PLANNING CONSULTATION RESPONSE

Application No	2026/0612
Proposal	2026 0612 New Café Bar & Retail Eldon St Main Stairwell Reinstatement, Music Venue and Associated Works Civic Hall Eldon Street
Address	Civic Hall Eldon Street
Date of Consultation Reply	120826
Consultee	Tony Wiles Senior Conservation Officer

Drawing Title
1F GA Existing

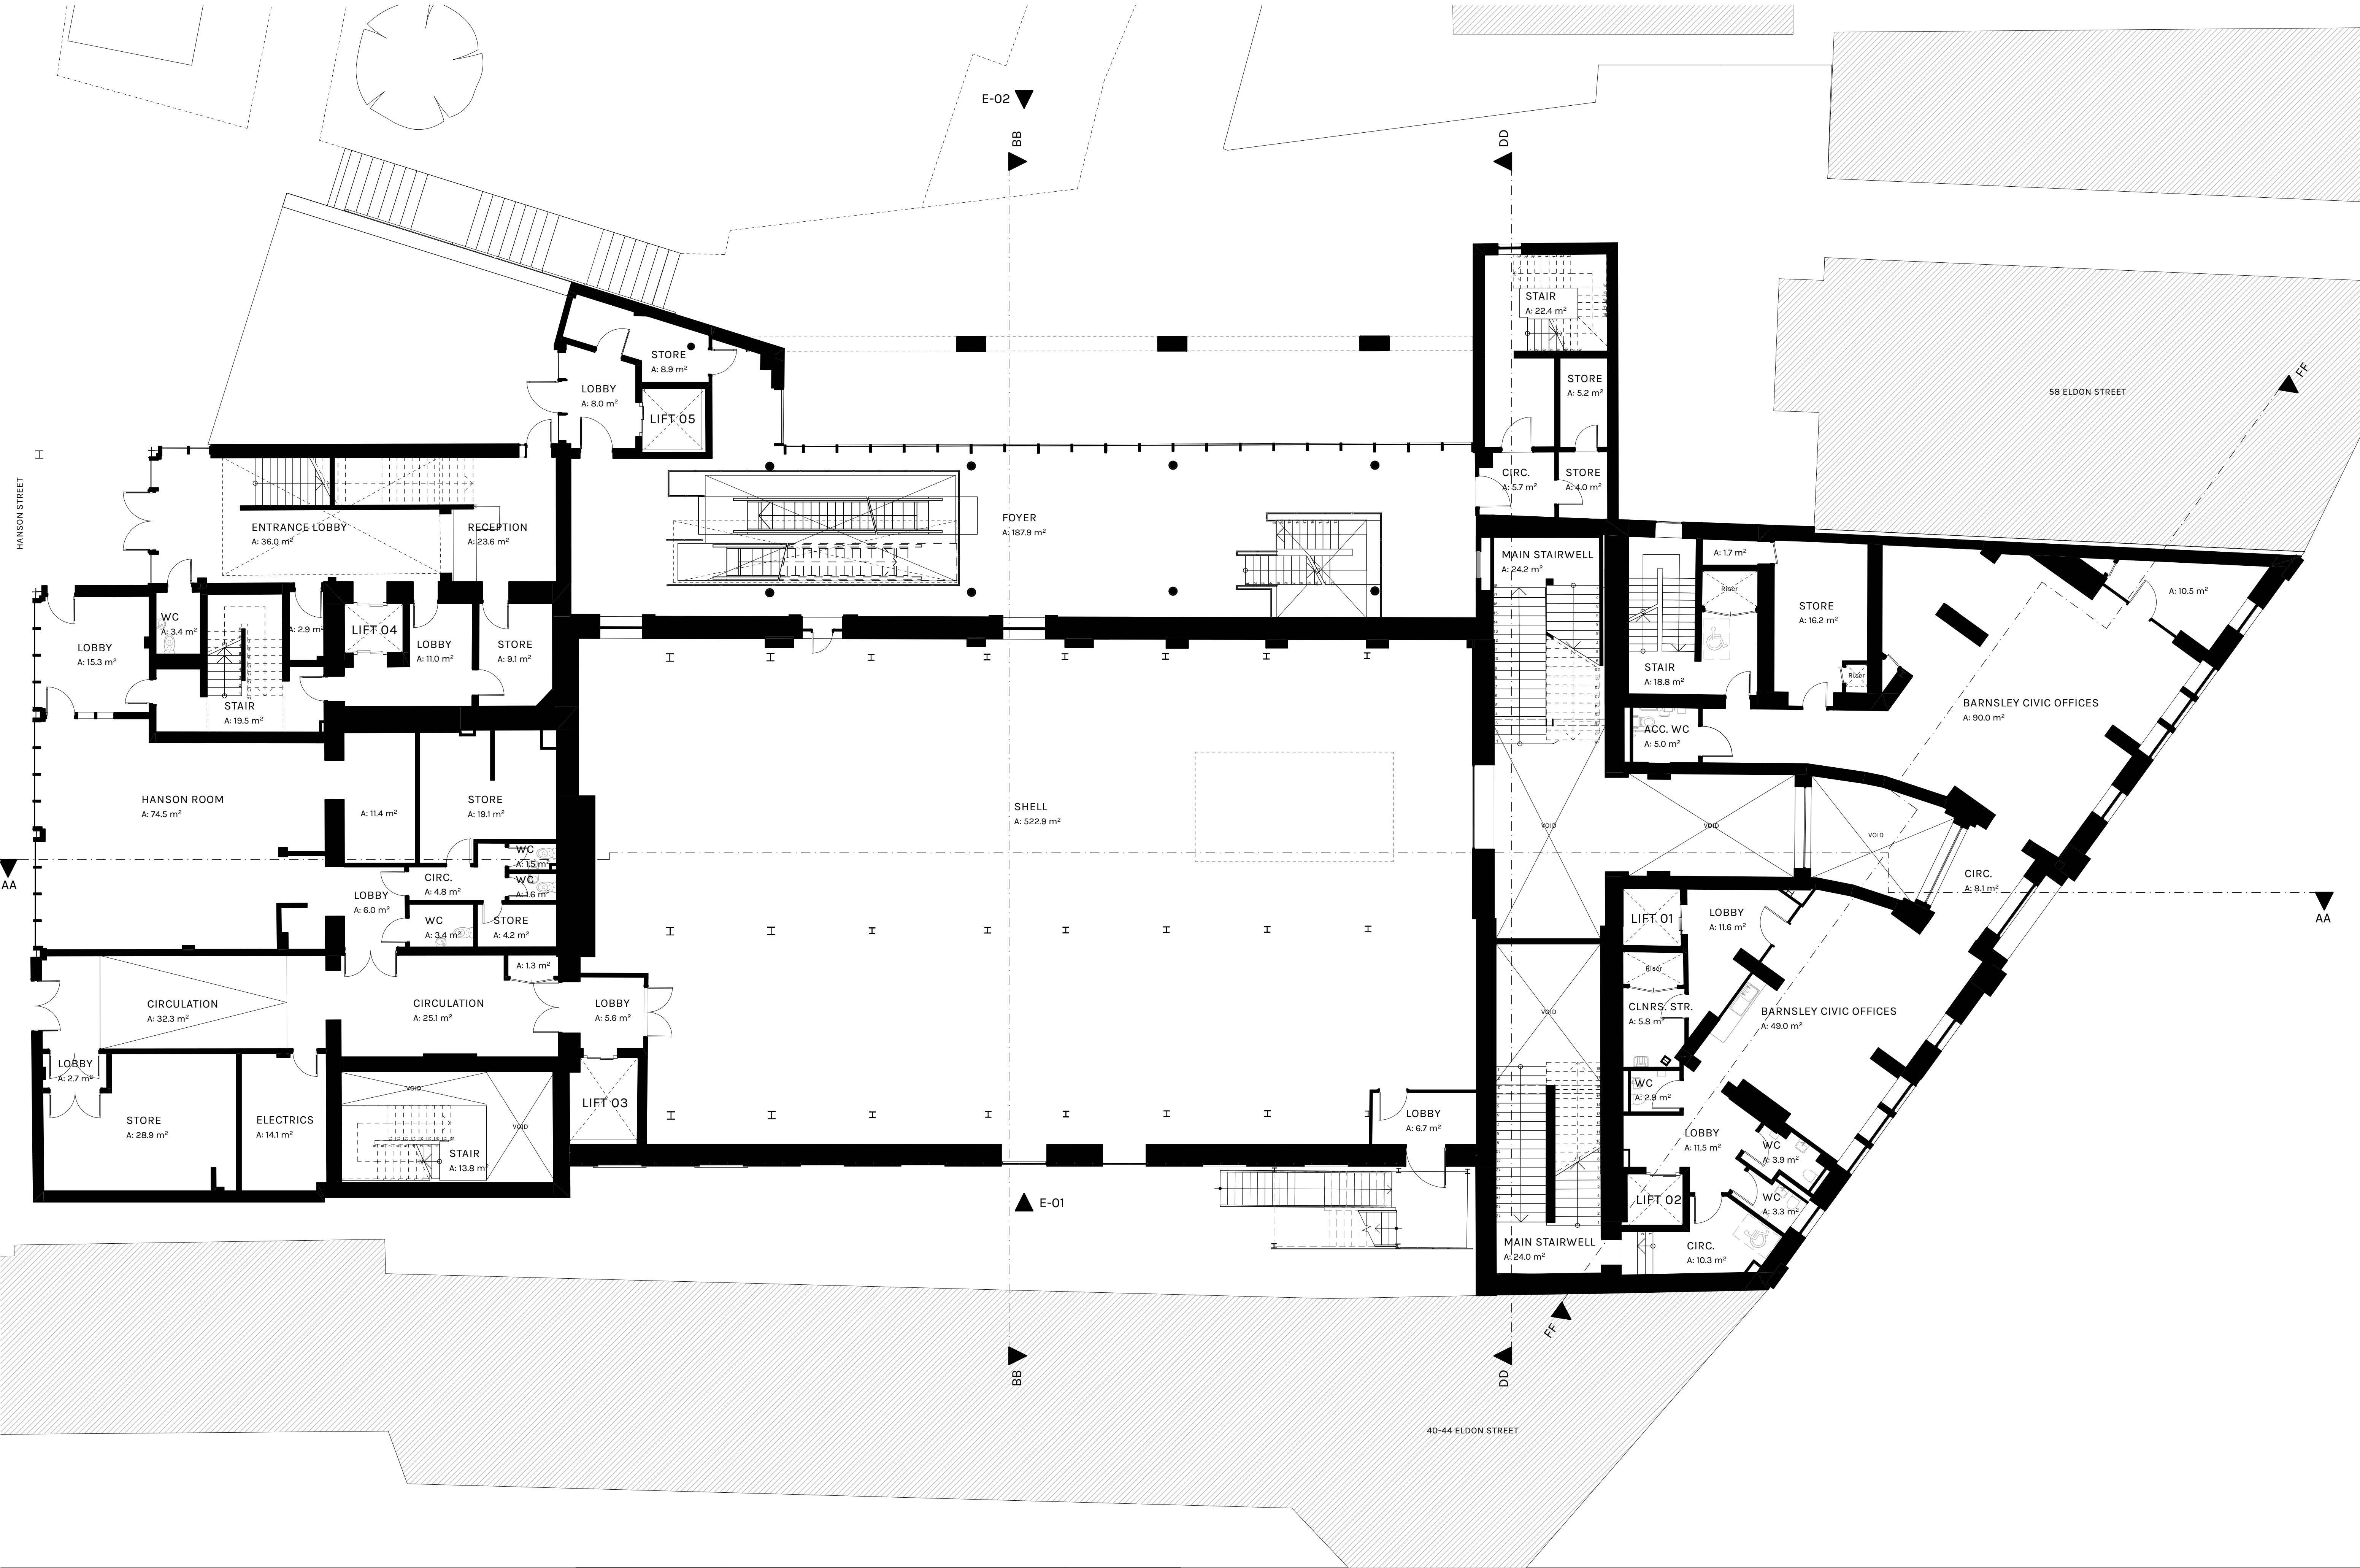
At first floor level the changes are limited to the southern stairwell partition removal (that cuts across several floors including the second floor), the escalator and stair removal, and some re-partitioning of the storerooms, lobby and W.C. adjacent to the Hanson Room. These are of no heritage interest. My only comment in relation to the first floor, relates to the infilling of the arched opening which is dressed in carved and moulded stonework that separates the Hanson Room and the existing lobby immediately to the east. I do not object to the blocking of this doorway but request the dressed stonework of the archway remains fully visible and expressed. This should be achieved by setting back the infill of the opening to the east by circa 200mm leaving the dressed stonework fully on show. Updated or amended plans should show this.

At first floor level, the arched opening dressed in carved and moulded stonework that separates the Hanson Room and the existing lobby immediately to the east is proposed to be infilled. I do not object to the blocking of this doorway but request the dressed stonework of the archway remains fully visible and expressed. This should be achieved by setting back the infill of the opening to the east by circa 200mm leaving the dressed stonework fully on show. Updated or amended plans should show this.

Drawing Title
B1 GA Proposed Phase 1
Project code
945BCP
Status:
D5
Revision:
P02
Originator
BLA
Volume
ZZ
Level
B1
Type
DR
Role
A
Number
0209
Status description:
Suitable for Approval by Statutory Authorities
Revision description:
Planning and LBC
Drawn by:
JR
Checked by:
GS

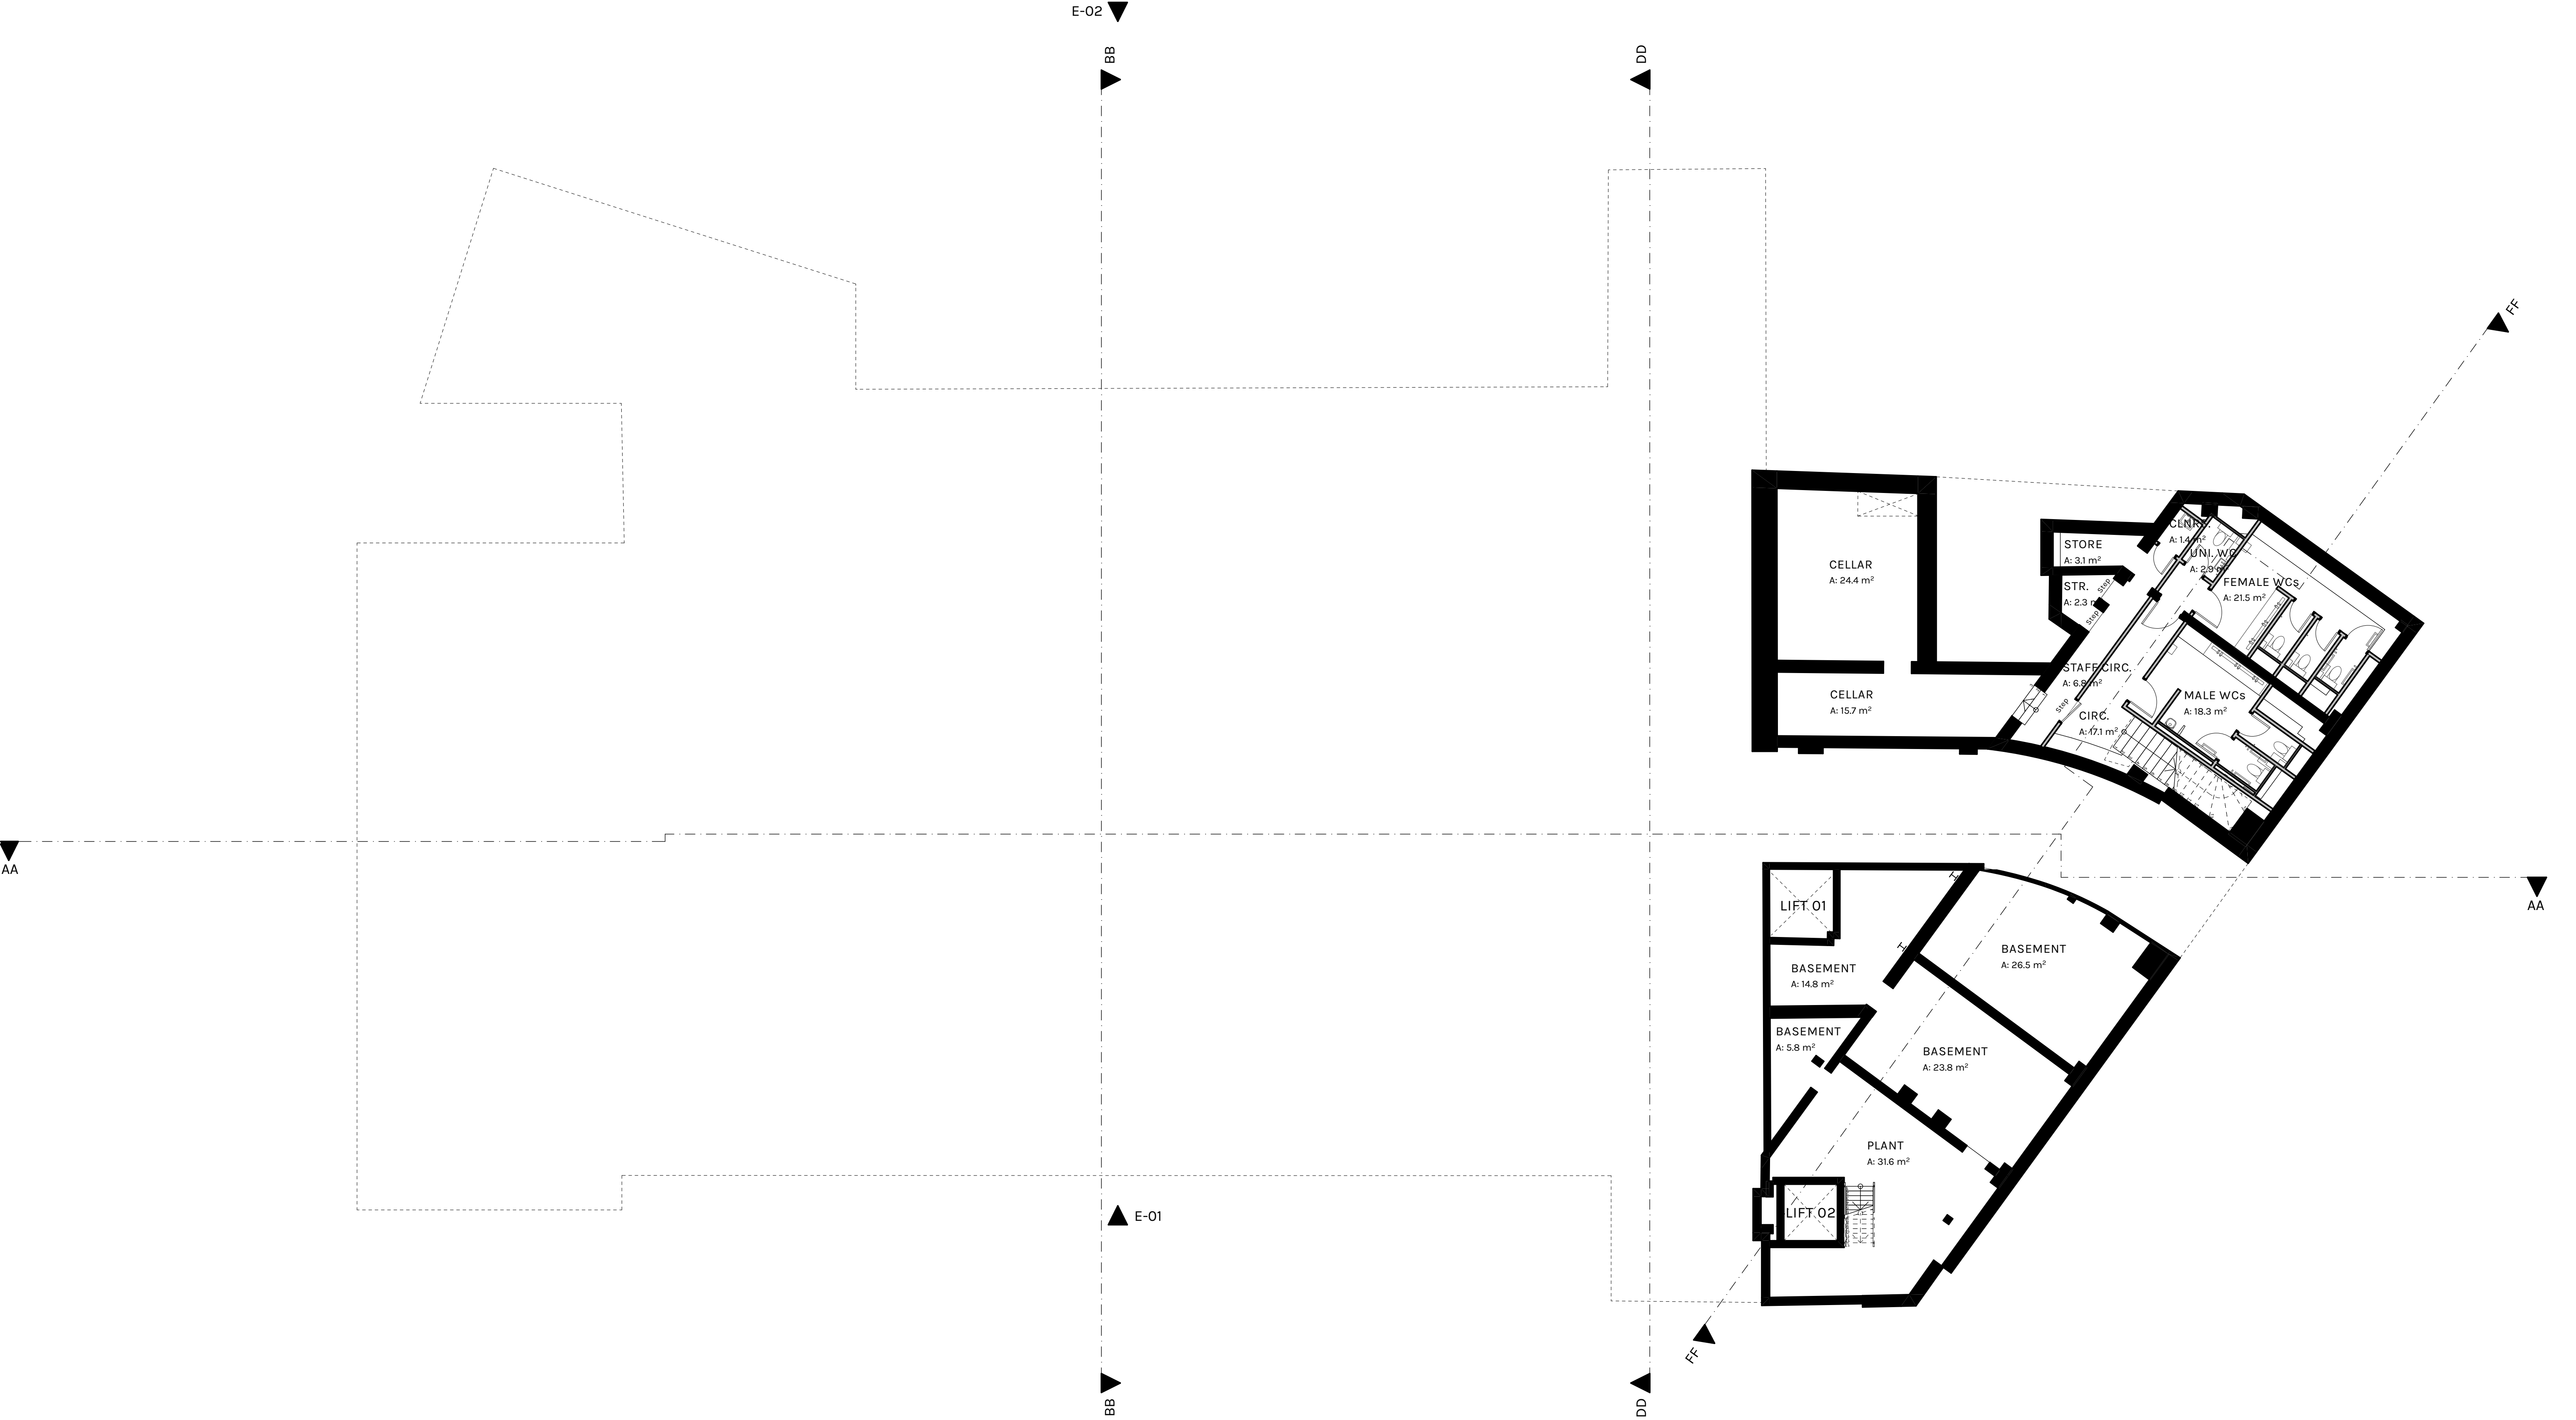
The works at basement level are focussed on two existing spaces beneath the existing flexible spaces (at ground floor level) at the northeastern corner that fronts Eldon Street. The plans indicate that an existing access hatch will be altered and extended to create stair access to the basement level. Within the basement, male and female toilets are proposed, with access to the rear cellars via a new rear wall opening and an enlarged opening in the floor slab for a barrel drop. Currently, the floor level provides insufficient headroom requiring the lowering of the floor slab. To create the new toilets, new partition walls are shown with a 500mm offset to avoid existing foundations and walls. I see no issues in principle with the works given the existing floor is entirely modern, and the basement level is currently a functional and inaccessible space. The proposal involves limited removals or historic fabric interventions. However, there are a handful of new openings formed in walls and floors, but these are reasonably justified to allow access and the utility of the space. I am also aware that the dividing wall between the two existing spaces may require removal to facilitate adequate space. If this is required, either amended plans, or a variation to any approved plans will be required. The lowering of the slab will however require a watching brief and input from a qualified archaeologist able to do the works. I've discussed this with Andrew Lines of the South Yorkshire Archaeology Service who has suggested we will require a written scheme of investigation which will need approving via condition. Subsequently, the archaeological monitoring will need to proceed in accordance with this.

Note: if the dividing wall within the basement needs to be removed, we will need the detail of this demolition either via amended plans or a variation to condition (of the approved plans) if approved.

- Upon commencement of the works, details of the basement level mechanical extract, including the exhaust location and its appearance shall be submitted and approved in writing. Development shall be carried out in accordance with the approved details

If the dividing wall within the basement needs to be removed, we will need the detail of this demolition either via amended plans or a variation to condition (of the approved plans) if approved.
